Our ref: STH09/02207/07
Contact: Andrew Lissenden 0418 962 703
Your ref: MP08_0143-Mod-3

BASS POINT QUARRY PROJECT – MODIFICATION 3 (MP 08_143 MOD 3)

Transport for NSW (TfNSW) refers to the notification it received on 8 December 2021 regarding the above application to modify the project approval for the Bass Point Quarry Project.

Figure 2 | Existing approved site layout and transport route

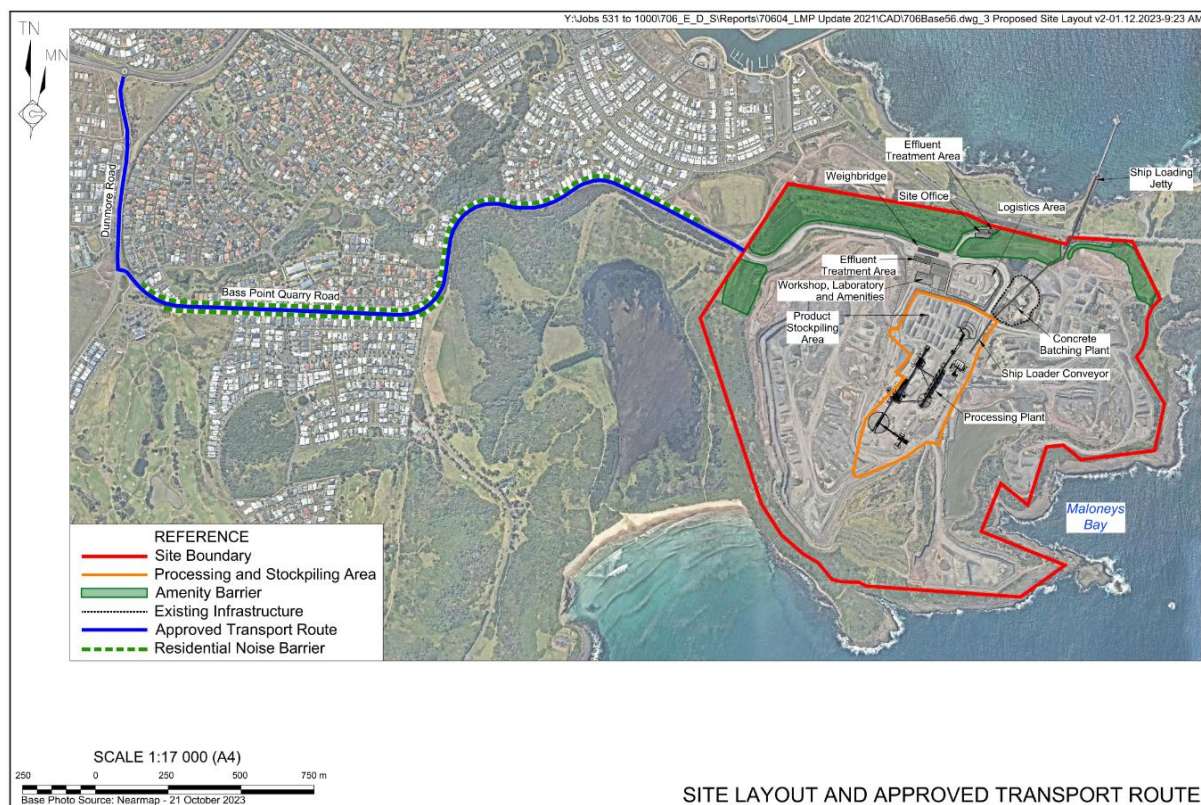
TfNSW is not supportive of the applicant's position that the proposed modification "*would not result in an increase of any Quarry related heavy vehicle movements on the approved transport route*" and "*No traffic related impacts would occur from the transportation of material to the Quarry Site that would not already be assessed as part of external developments*". TfNSW believes that the importation of VENM and ENM rehabilitation materials into the quarry and any traffic related impacts will need to be assessed as part of this development and not as part of non-related developments from which the VENM and ENM will be obtained. No assessment of traffic related impacts as a result of the proposed changes has been provided as part of the current application. To ensure adequate consideration is given to traffic related impacts TfNSW requests the applicant prepare a supporting traffic assessment for the proposed importation of VENM and ENM that includes, but is not limited to, to the following:

- a) Details on the maximum number of additional vehicle movements (daily and yearly) that will deliver VENM and/or ENM rehabilitation materials into the quarry including how these numbers correlate to the daily and annual limits for which approval is being sought.
- b) Details on the type of vehicle(s) and their maximum carrying capacity that will deliver the VENM and/or ENM rehabilitation materials into the quarry.
- c) Confirmation if vehicles delivering VENM and/or ENM rehabilitation materials will be back-loading or will be separate from vehicles collecting materials from the quarry.
- d) Details on how the numbers of vehicles associated with the delivery of VENM and ENM will be monitored to ensure ongoing compliance.
